Subject: Rezoning Petition Review

Rezoning Petition #: 22-044

Location of Property: Approximately 3.67 acres located on the east side of N Tryon St, west of Matheson Ave and north of N Brevard St.

RZ-1

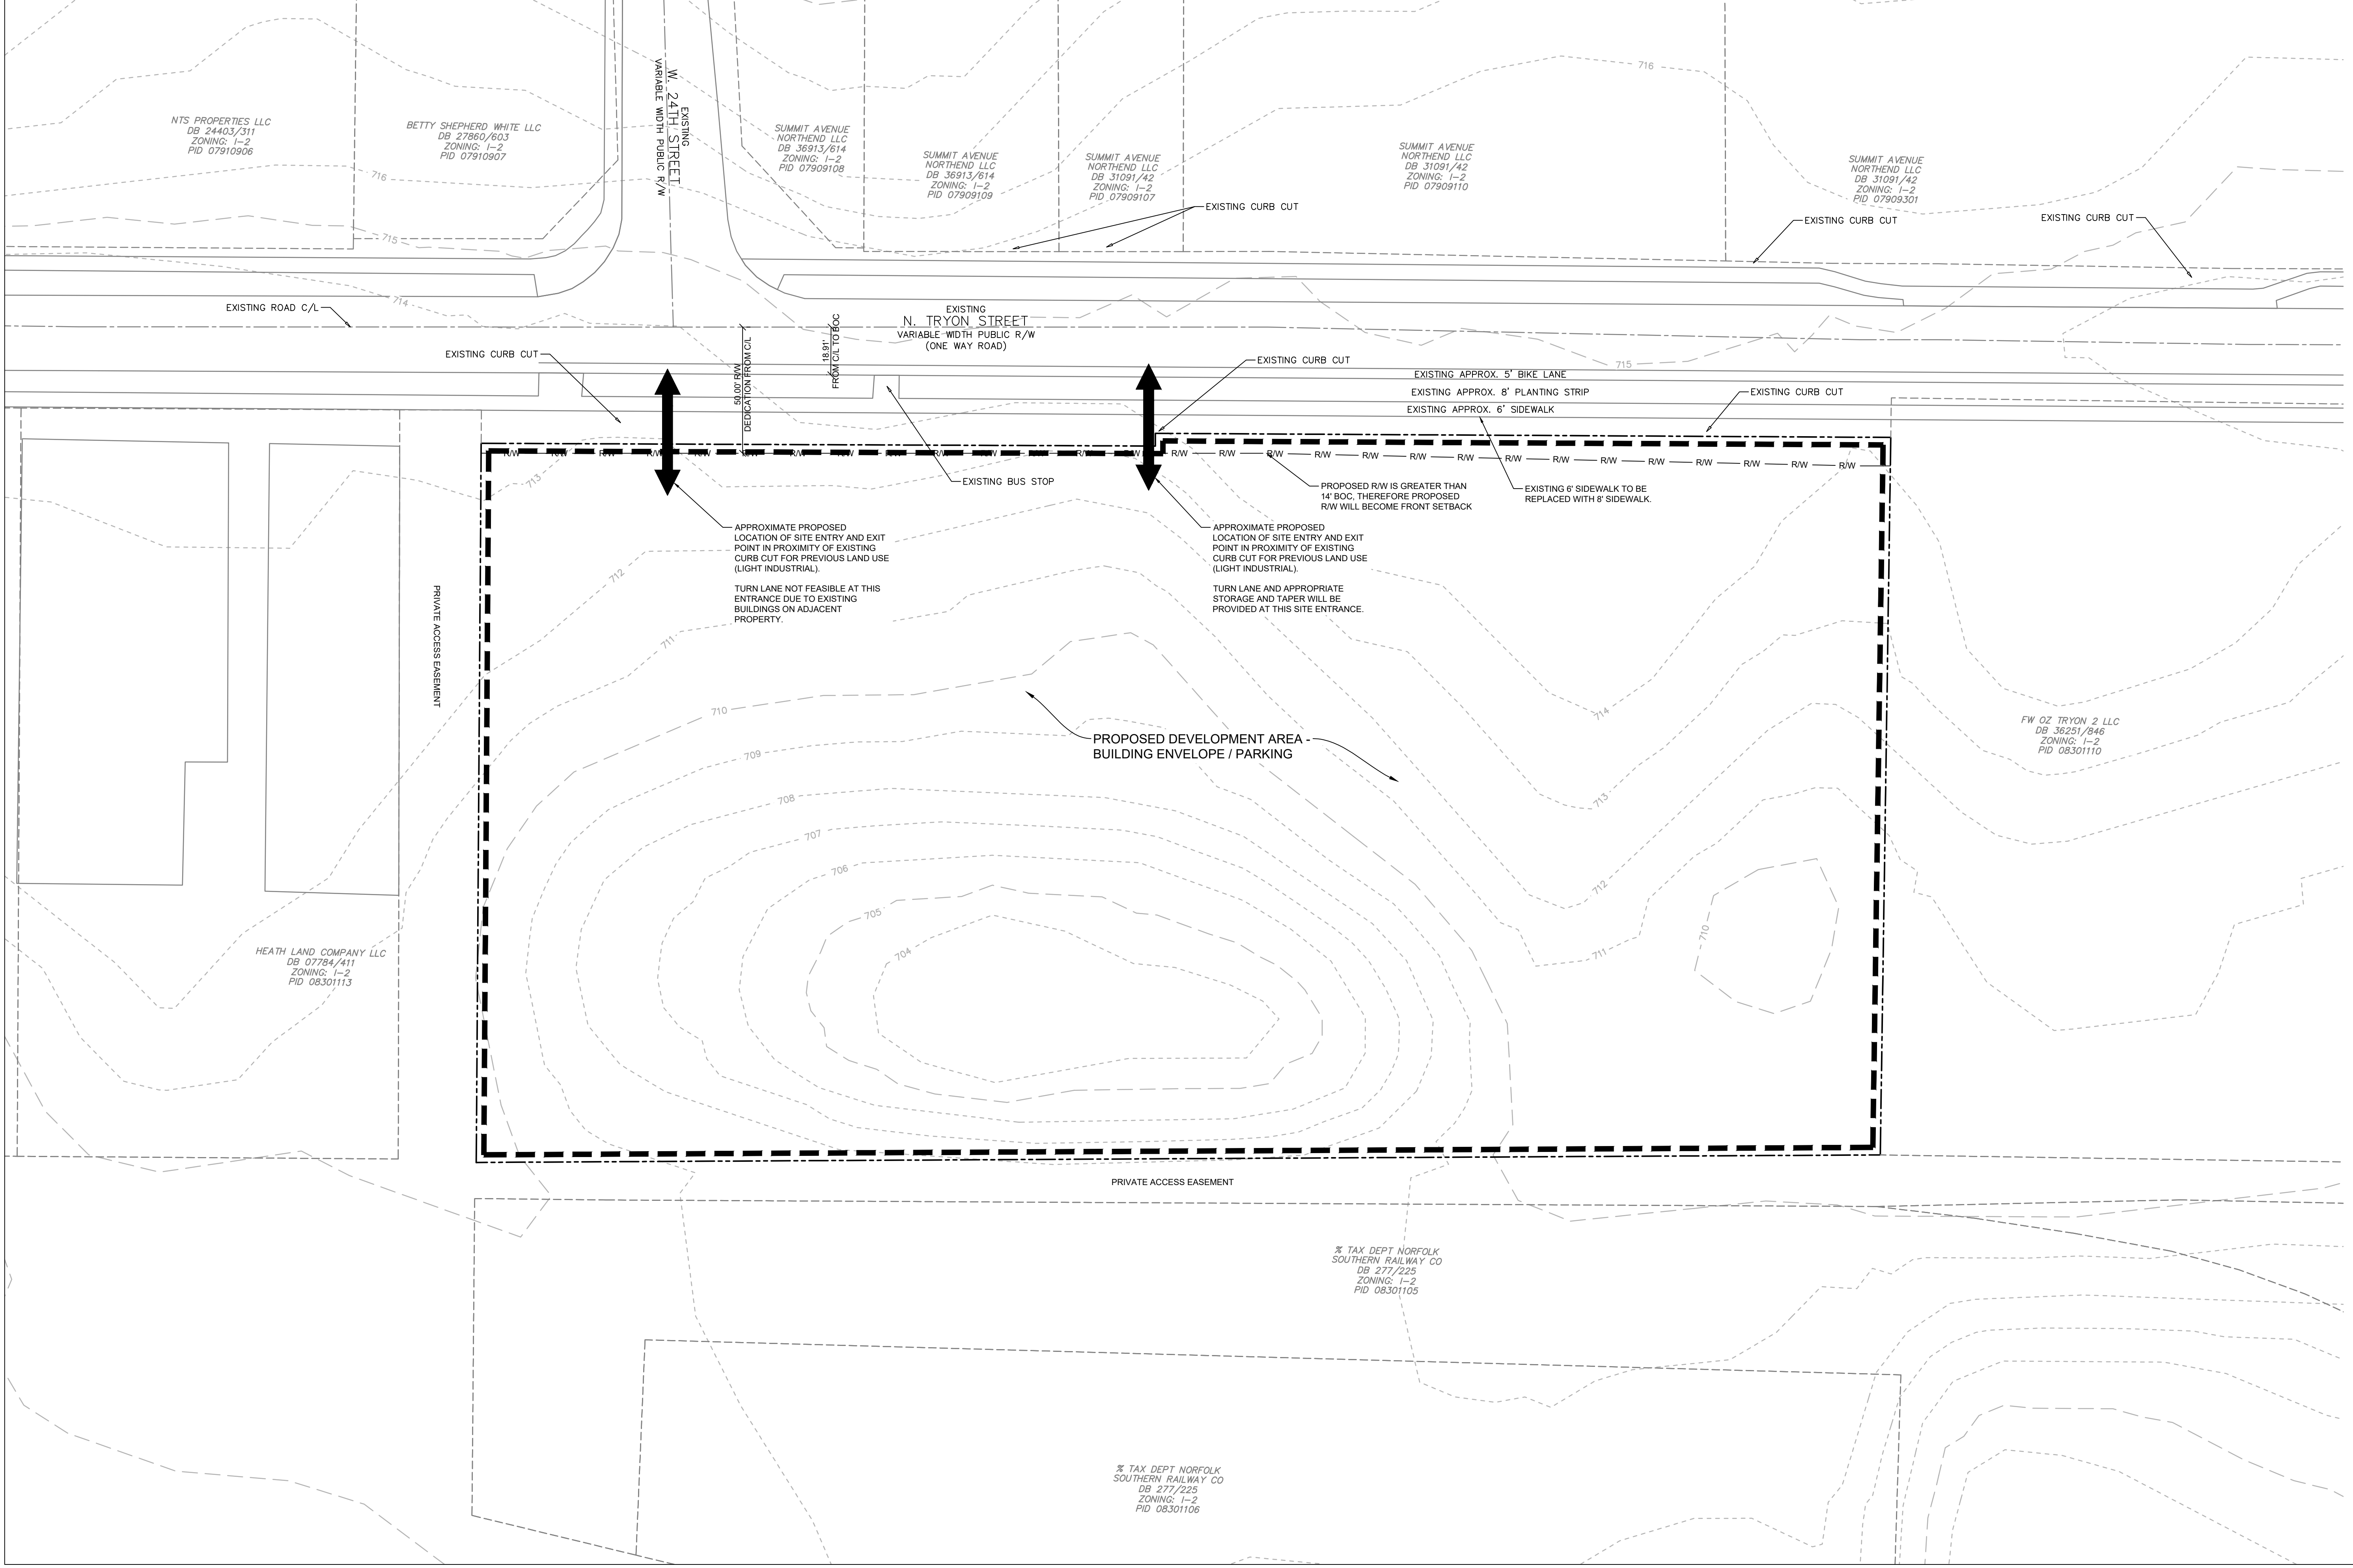
This property drains to Upper Little Sugar Creek, which is an impaired/degraded stream, and may contribute to downstream flooding. This project has the opportunity to mitigate future impacts to this stream, therefore, Storm Water recommends placing the following notes on the plan:

For defined watersheds greater than 24% built-upon area (BUA), construct water quality stormwater control measures (SCMs) designed for the runoff generated from the first 1-inch of rainfall for all new and redeveloped BUA associated with the project. SCMs must be designed and constructed in accordance with the Charlotte-Mecklenburg BMP Design Manual.

For defined watersheds greater than 24% built-upon area, control the entire volume for the 1-year, 24-hour storm for all new and redeveloped BUA associated with the project. Runoff volume drawdown time shall be in accordance with the Charlotte-Mecklenburg BMP Design Manual.

For commercial projects with greater than 24% BUA, control the peak to not exceed the predevelopment runoff rates for the 10-yr, 6-hr storm and perform a downstream flood analysis to determine whether additional peak control is needed and if so, for what level of storm frequency, or if a downstream analysis is not performed, control the peak for the 10-yr and 25-yr, 6-hour storms.

For residential projects with greater than 24% BUA, control the peak to not exceed the predevelopment runoff rates for the 10-year and 25-year, 6-hour storms or perform a downstream analysis to determine whether peak control is needed, and if so, for what level of storm frequency.
